**The Planning Act 2008, AQUIND Limited, proposed AQUIND Interconnector Project
Oral transcript in response to the Examining Authority's (ExA) Issue Specific
Hearing 1 (ISH 1) Agenda and Issue Specific Hearing 3 (ISH 3) Agenda**

On 6 January 2020, the Marine Management Organisation (the "MMO") received notice under section 56 of the Planning Act 2008 (the "2008 Act") that the Planning Inspectorate ("PINS") had accepted an application made by AQUIND Limited (the "Applicant") for a development consent order (the "DCO Application") (MMO ref: DCO/2018/00016; PINS ref: EN020022).

The DCO Application seeks authorisation to construct and operate an electricity interconnector with a net transmission capacity of 2000 megawatts between France and the UK (the "Project").

Drawing file: EN020022 / EN020022-000605-6.2.3.7 ES - Vol 2 - Figure 3.7 Atlantic Cable Crossing.pdf

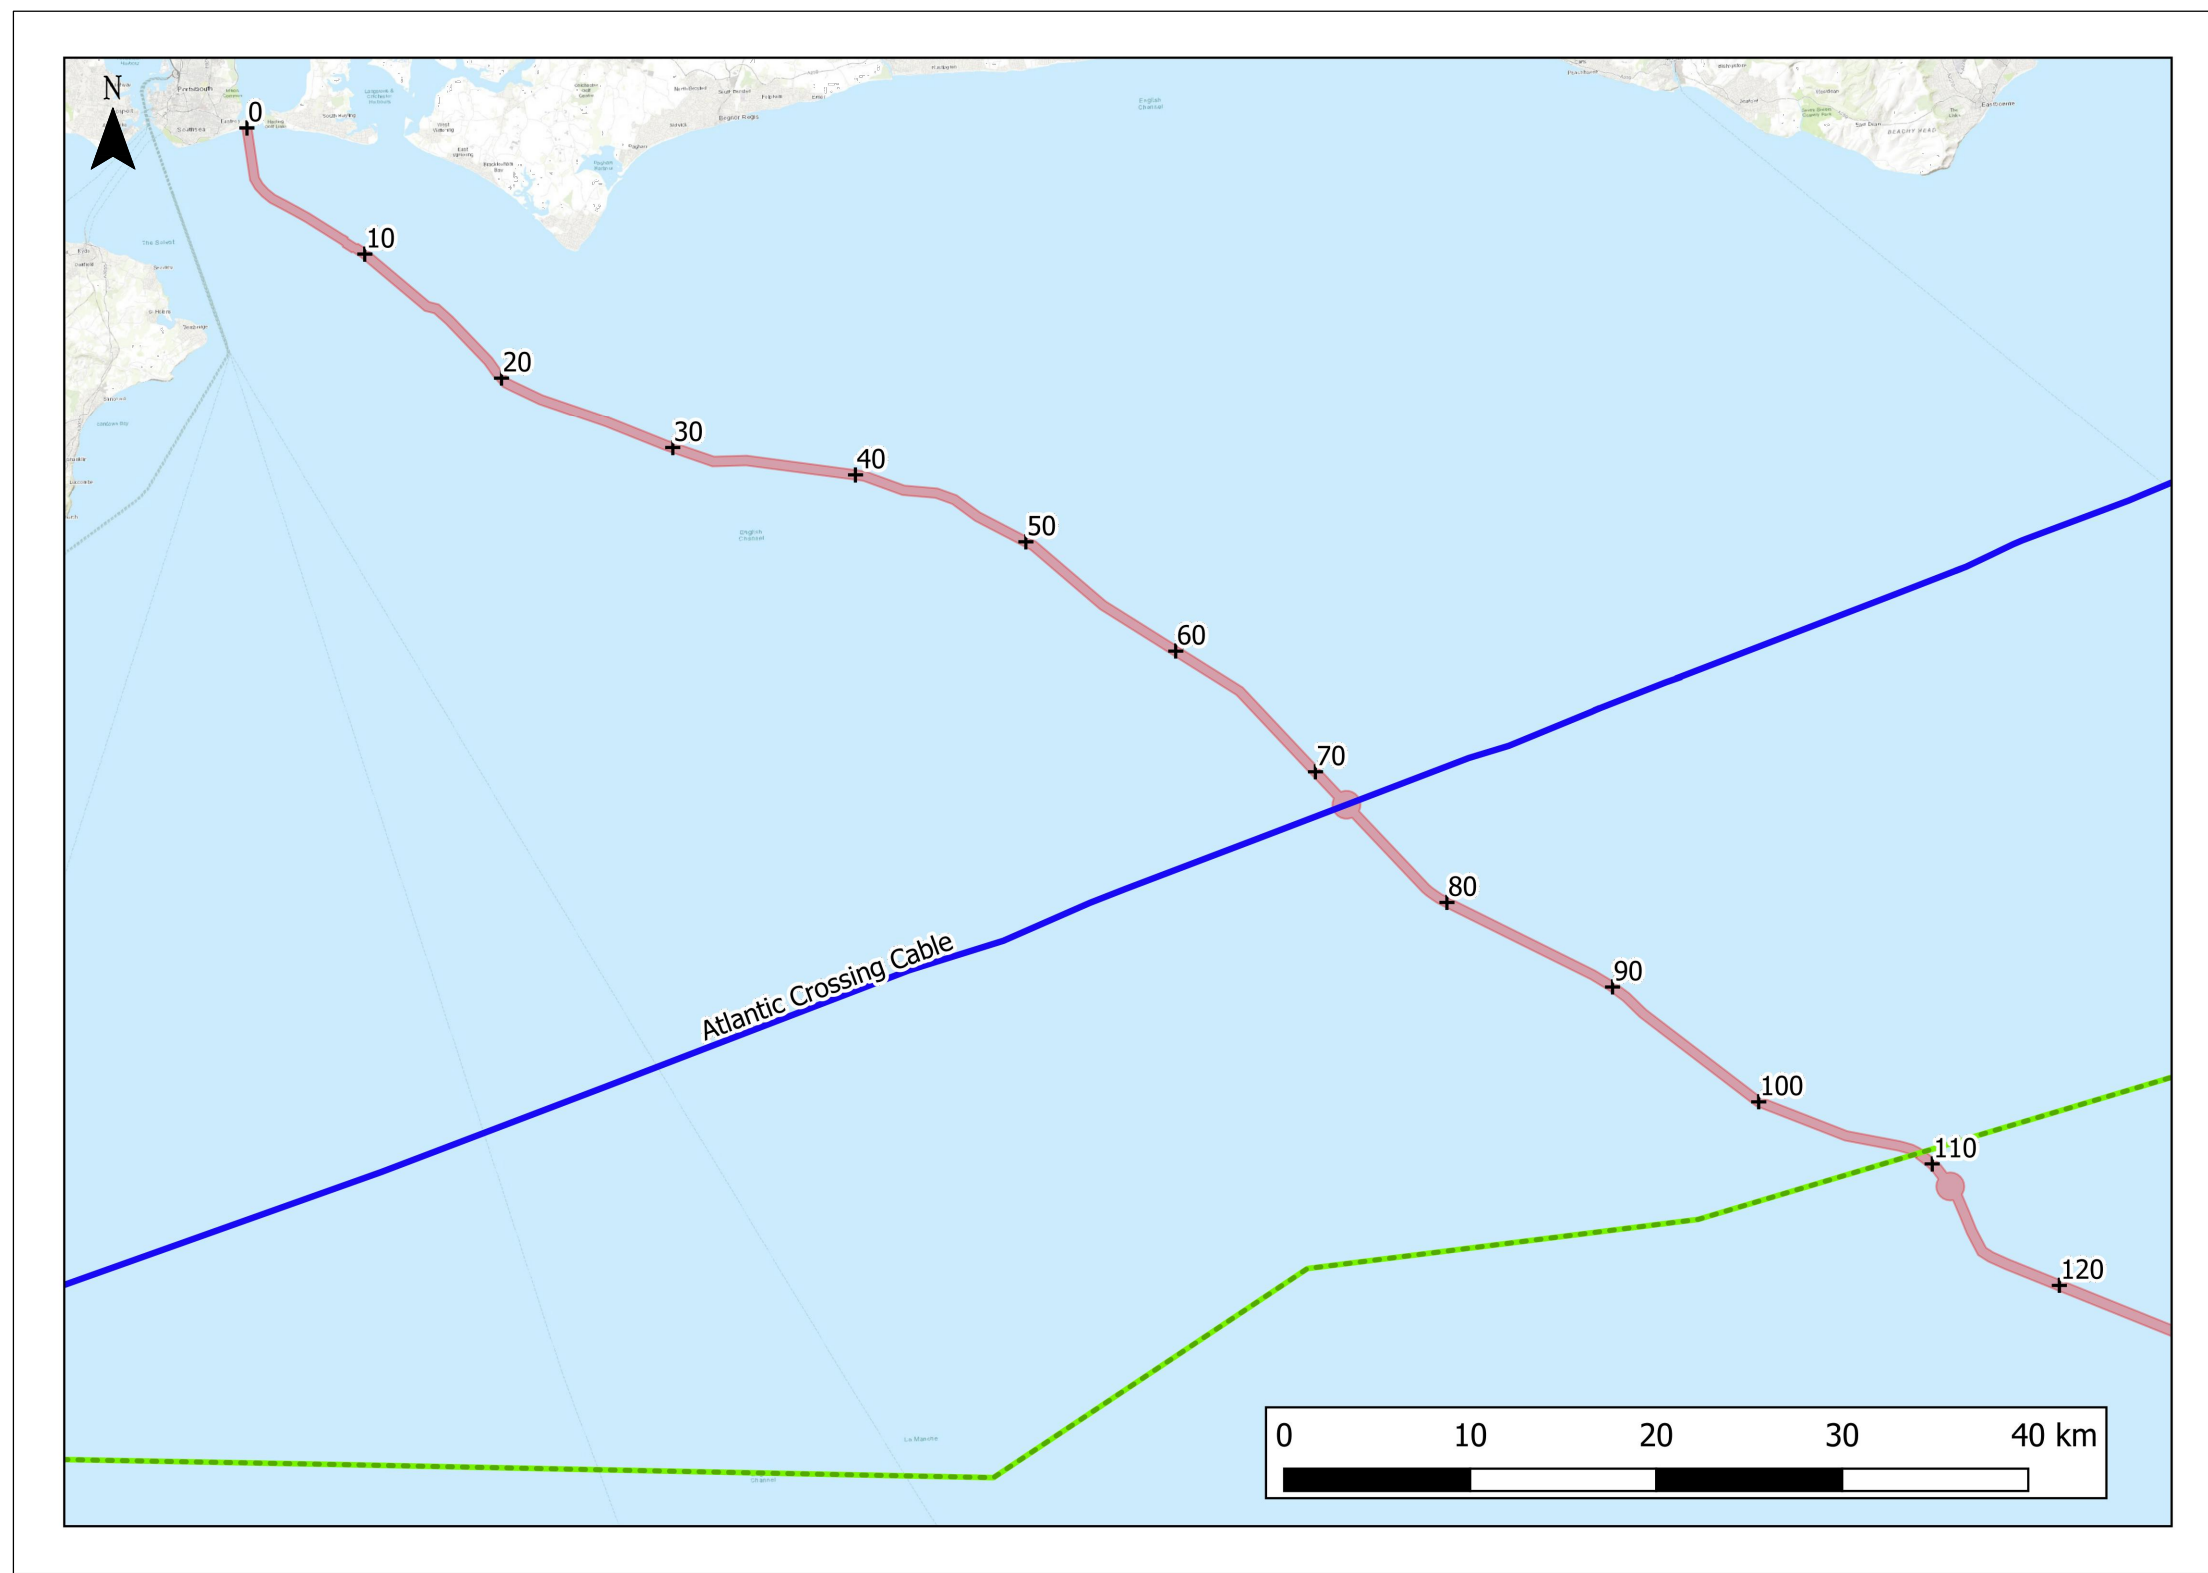
The maximum parameters within Schedule 15, Part 2 Condition 1 already include provision of cable protection for the Atlantic Cable Crossing. MMO previously agreed with (in the SoCG) that presenting this parameter as 'area' (rather than volume) is appropriate. The Applicant has however acknowledged the request for defining the length and area of the Atlantic Cable Crossing and advised they can accommodate this request.

The Applicant has proposed that rather than include this item in Part 2, paragraph 1 which would mean that the current parameters listed would need to be amended so that there is no double counting (and the details of which currently match the parameters as reported in all of the assessments and mitigation documentation), that additional text is added to Part 1, Paragraph 4(1) as follows;

(1) cable protection, including the Atlantic Cable Crossing cable protection (pre-lay berm, 100 m x 30 m and post-lay berms of approximately 600 m x 30 m) covering a maximum footprint of 37,800 m².

Further, the Applicant is content to amend Part 2, Condition 11 to include provision for details of scour/erosion around the Atlantic Cable Crossing, and the justification for any additional protection which may be required.

The MMO awaits for proposed wording for the condition from the Applicant.

Drawing file: EN020022 / EN020022-000954-6.8.2.8.1 HRA - Vol 2 - Figure 8.1 Location of In Combination Marine Projects.pdf

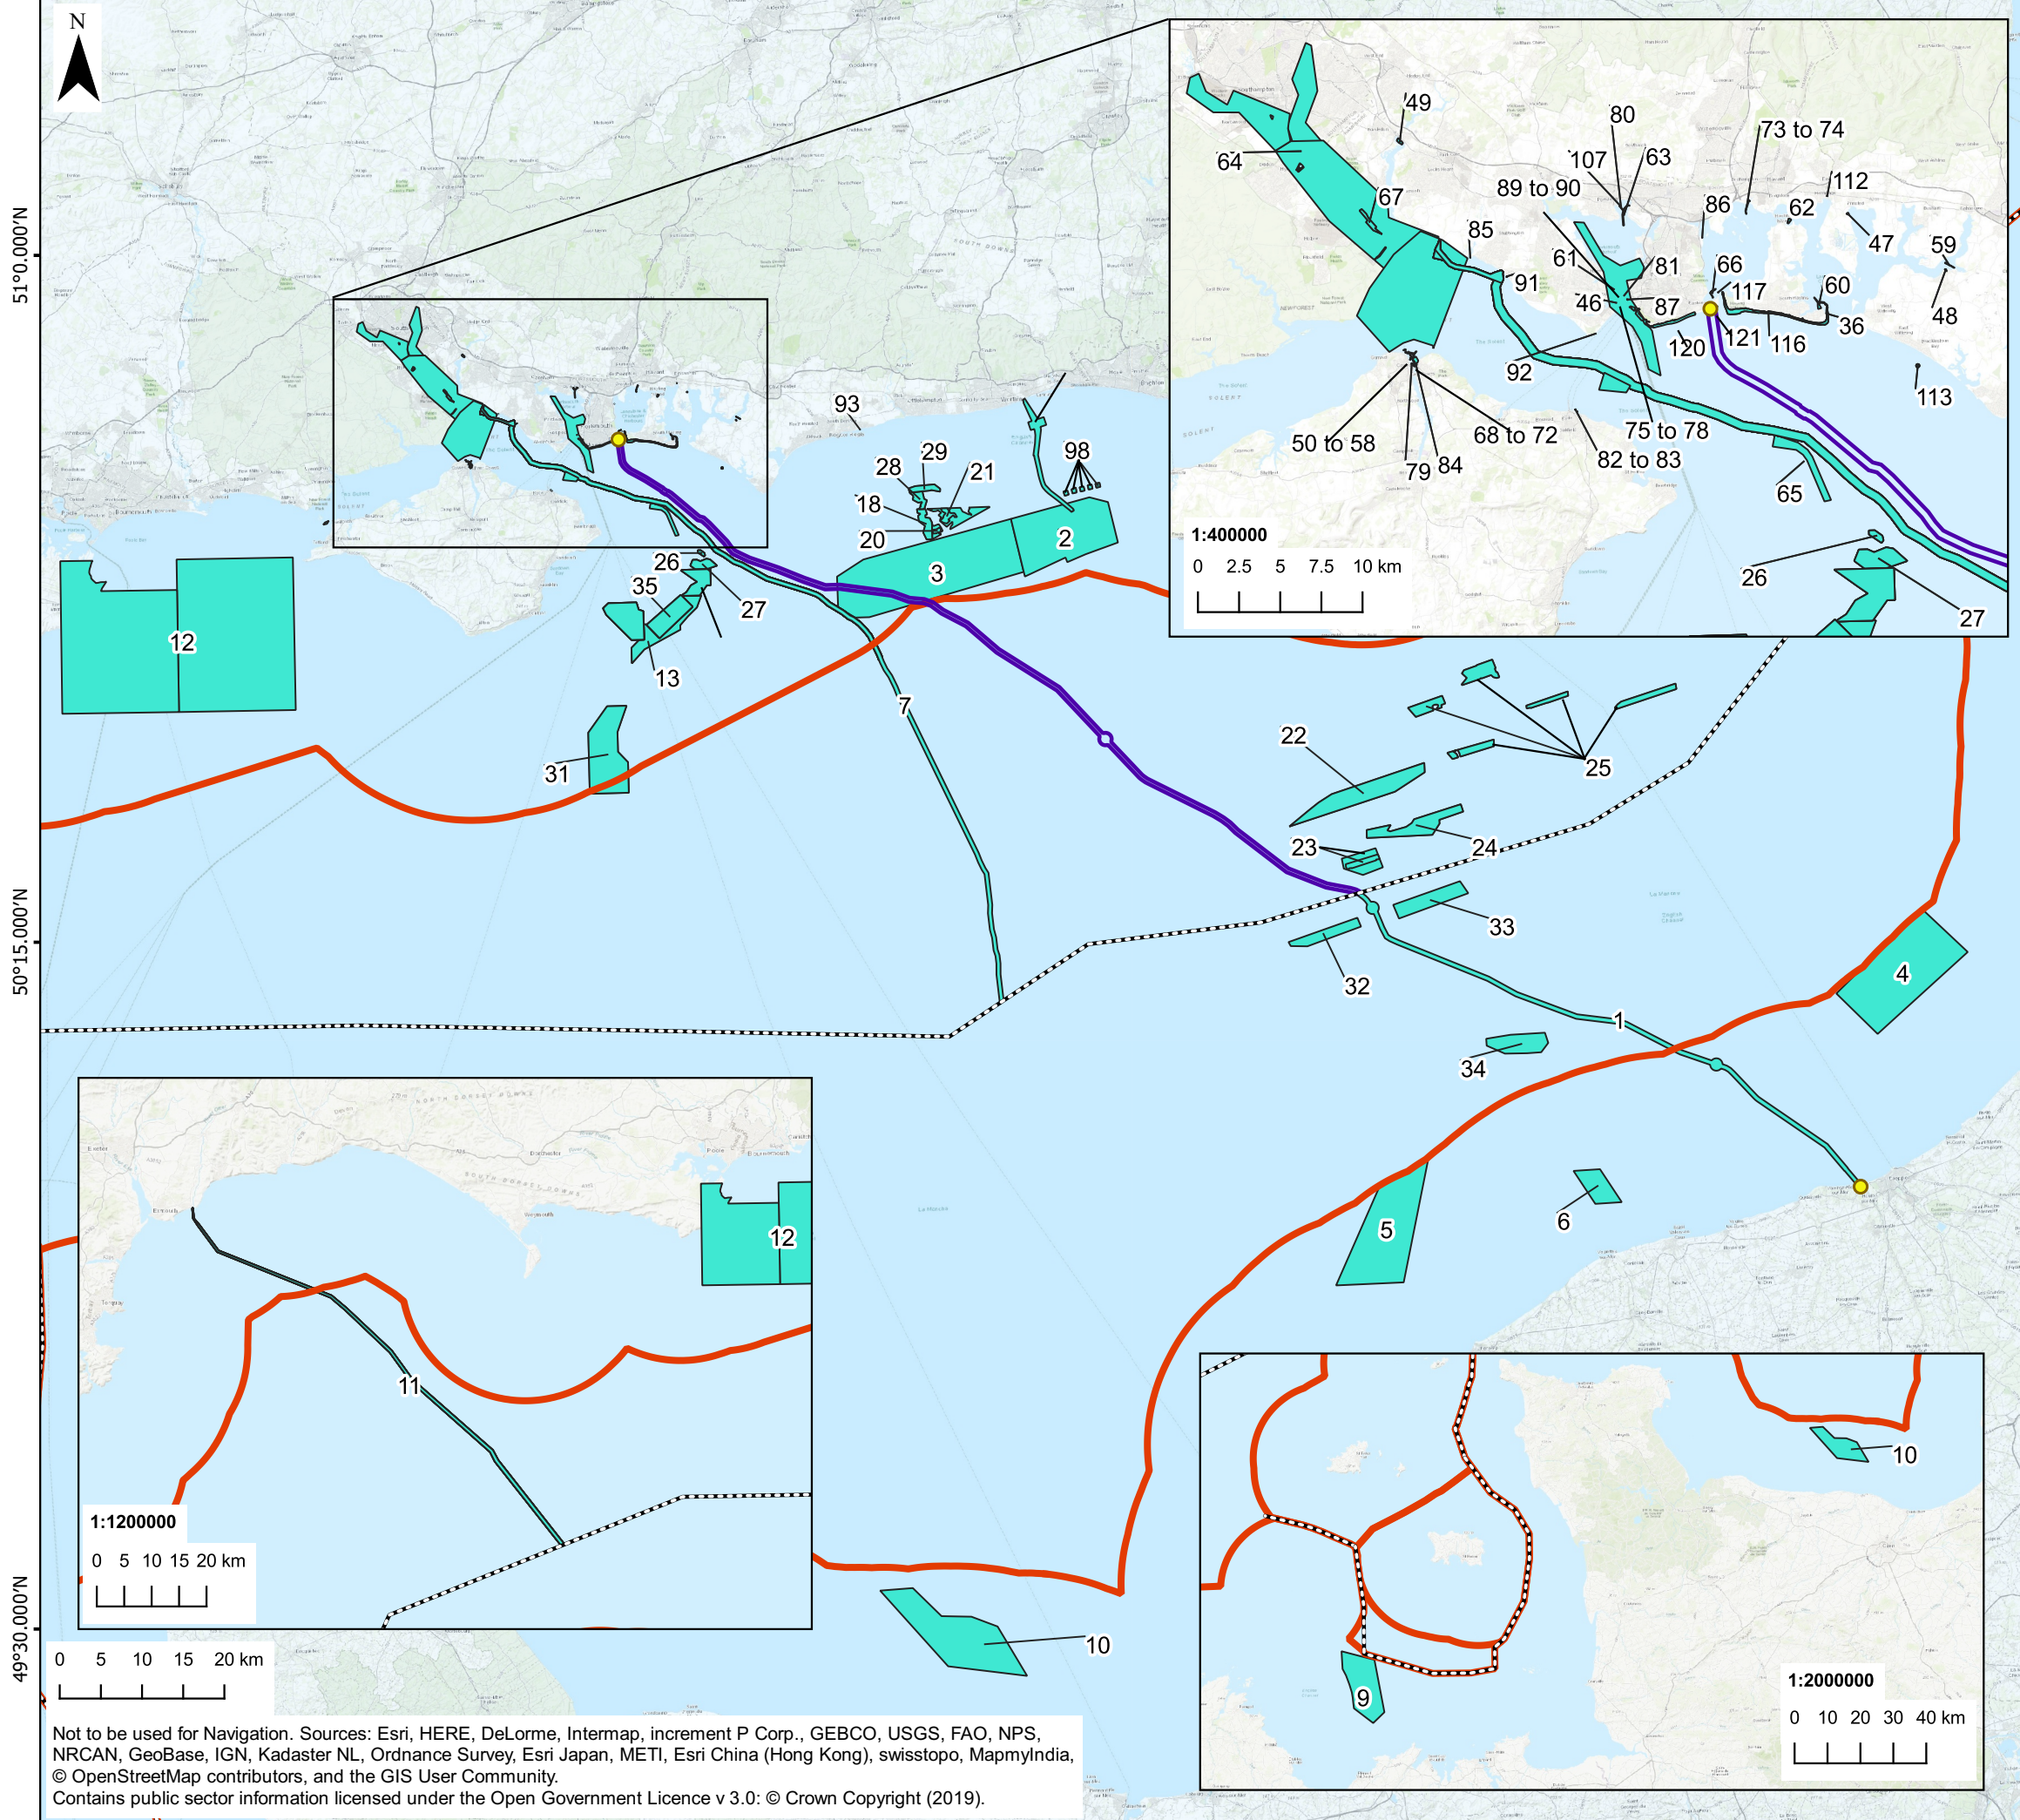
• Whilst it is stated that a precautionary approach was taken to determine the study areas for the baseline, could the Applicant provide reassurance that Figure 8.1 does not need updating to reflect the regional boundaries used in the ES? Are the MMO and Natural England content with the extent of the study area?

The MMO is content with the study area.
